The British Horse Society
Abbey Park,
Stareton,
Kenilworth,
Warwickshire CV8 2XZ

Raymond Cole, Planning Officer,
Arun District Council,
Arun Civic Centre,
Maltravers Road,
Littlehampton,
West Sussex,
BN17 5LF

Reference: Outline Planning Application F/4/20/OUT

Figure 39: Access from Ford Lane - Proposed

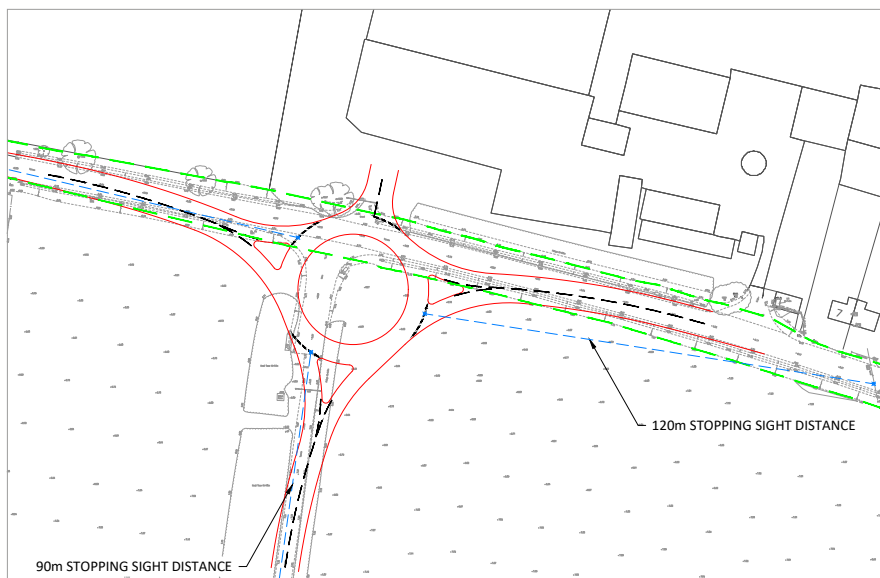
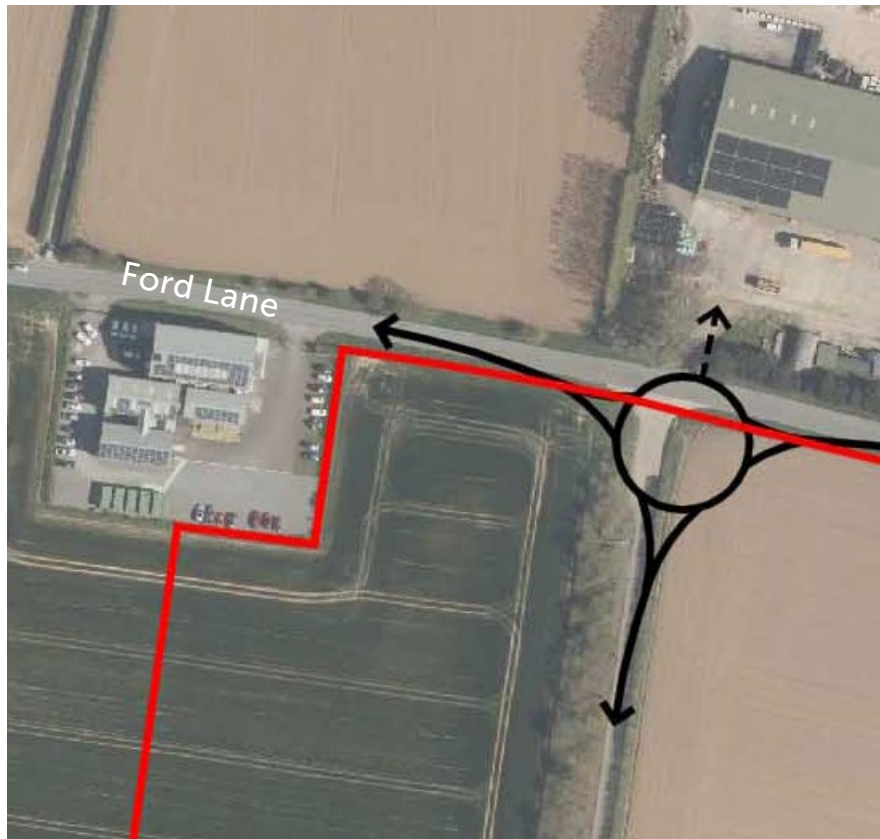
Ford Lane access is also via a roundabout, and from the outline plans I see it is the intention to have a grassed area with trees facing the lane. I would ask that an area be allowed for off road movement of horses for safety reasons coming past the industrial entrances on the north side of the road. With this roundabout, the allowing of crossing from grass to grass, with a defined point to do so would be safer than via grade on the roundabout. I would also ask that Caution Horses signs be positioned west of this roundabout, and at the Yapton Lane end for traffic turning into Ford Lane. This piece of lane is notorious for drivers going too fast, and there have been numerous incidents of vehicles overturning after mis judging a bend and going up one or other of the facing banks. Whilst signs won't mitigate against the idiot, they would at least be a warning to expect the unexpected.
